**SUBJECT: BRES2203-0010**  
**BUILDING RESIDENTIAL**

Here are the results of all Inspections located at **7150 NC 27 E:**

FOUNDATION PLAN
SCALE 1/4" : 1'

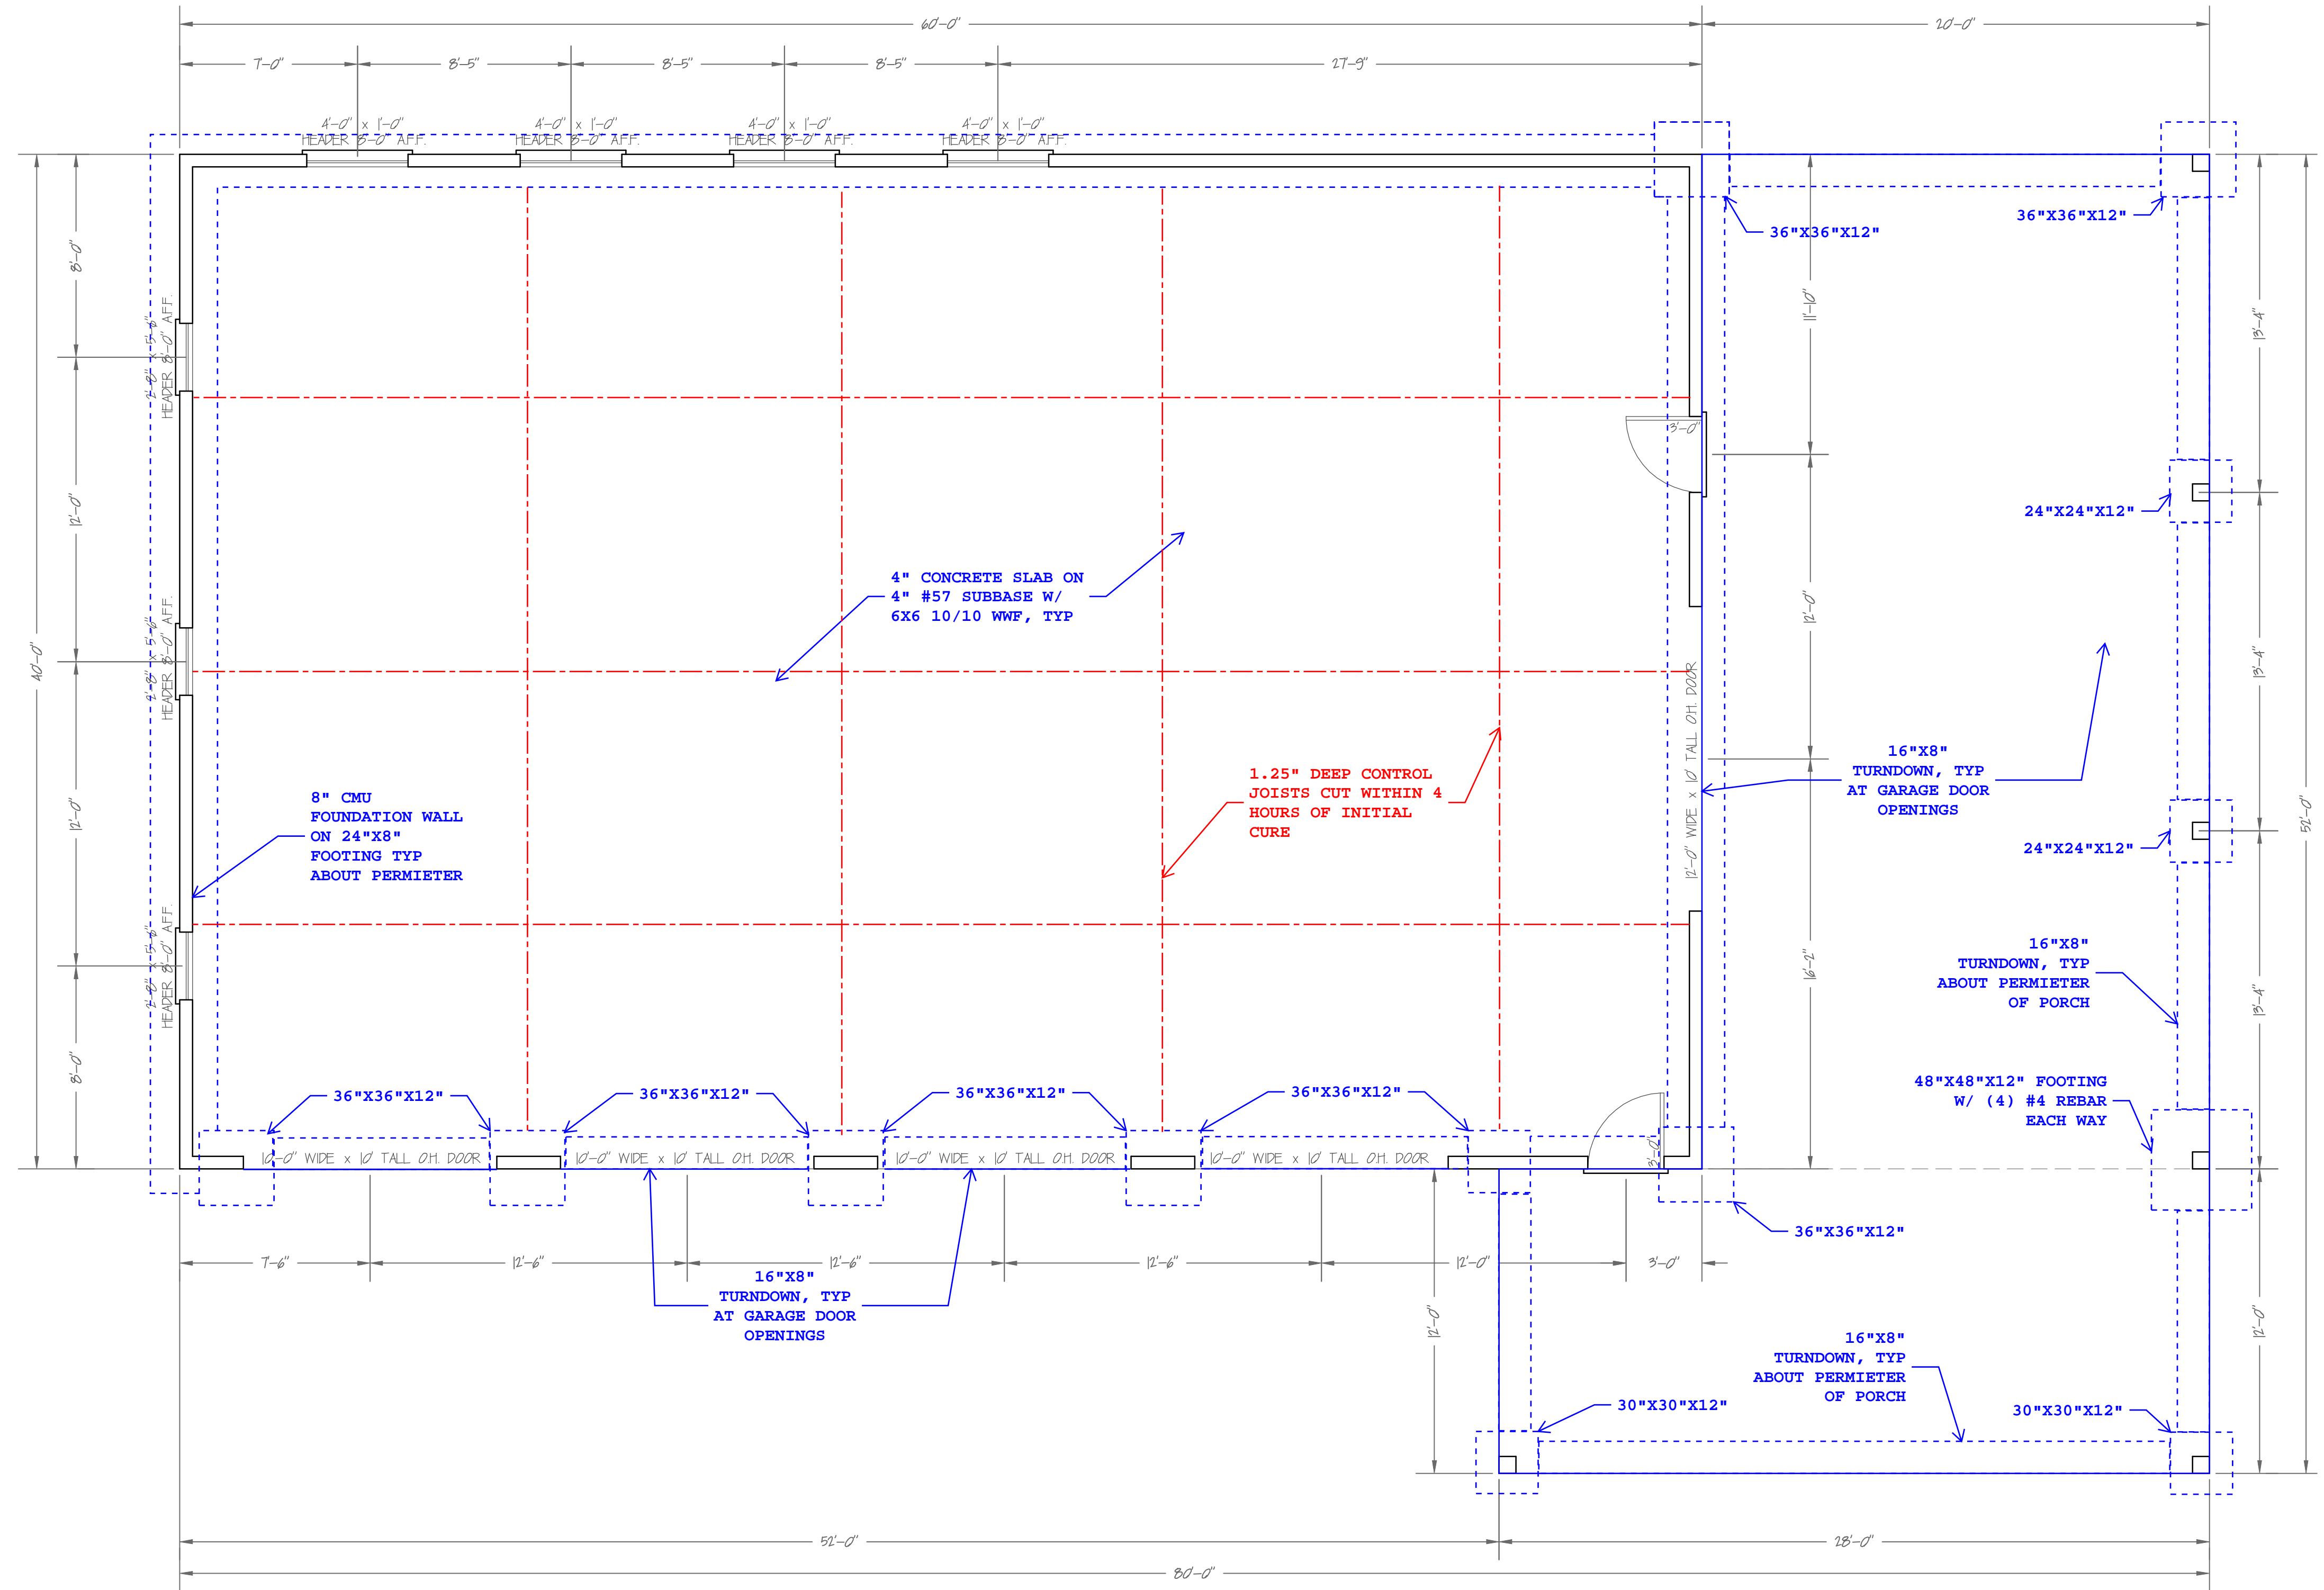
Inspection Type: MONO SLAB  
Scheduled Date/Time: 3/30/2022  
Completed Date/Time: 3/30/2022  
Inspector: Deen Taylor  
Result: DISAPPROVED  
Remarks:  
Notes: Cus req this be put on w/underslab trades  
No engineer plan for monolithic slab pour, only footing and stemwall

Inspection Type: MONO SLAB  
Scheduled Date/Time: 5/31/2022  
Completed Date/Time: 5/31/2022  
Inspector: Deen Taylor  
Result: DISAPPROVED  
Remarks:  
Notes: Original sealed plans called for stemwall slab. Monolithic slab was never inspected nor approved and now requires engineers approval

Notes: see eng letter  
see eng letter  
The sealed engineer letter must state that the monolithic slab that has been poured meets or exceeds the requirements of the slab originally designed by the engineer for the approved set of plans.
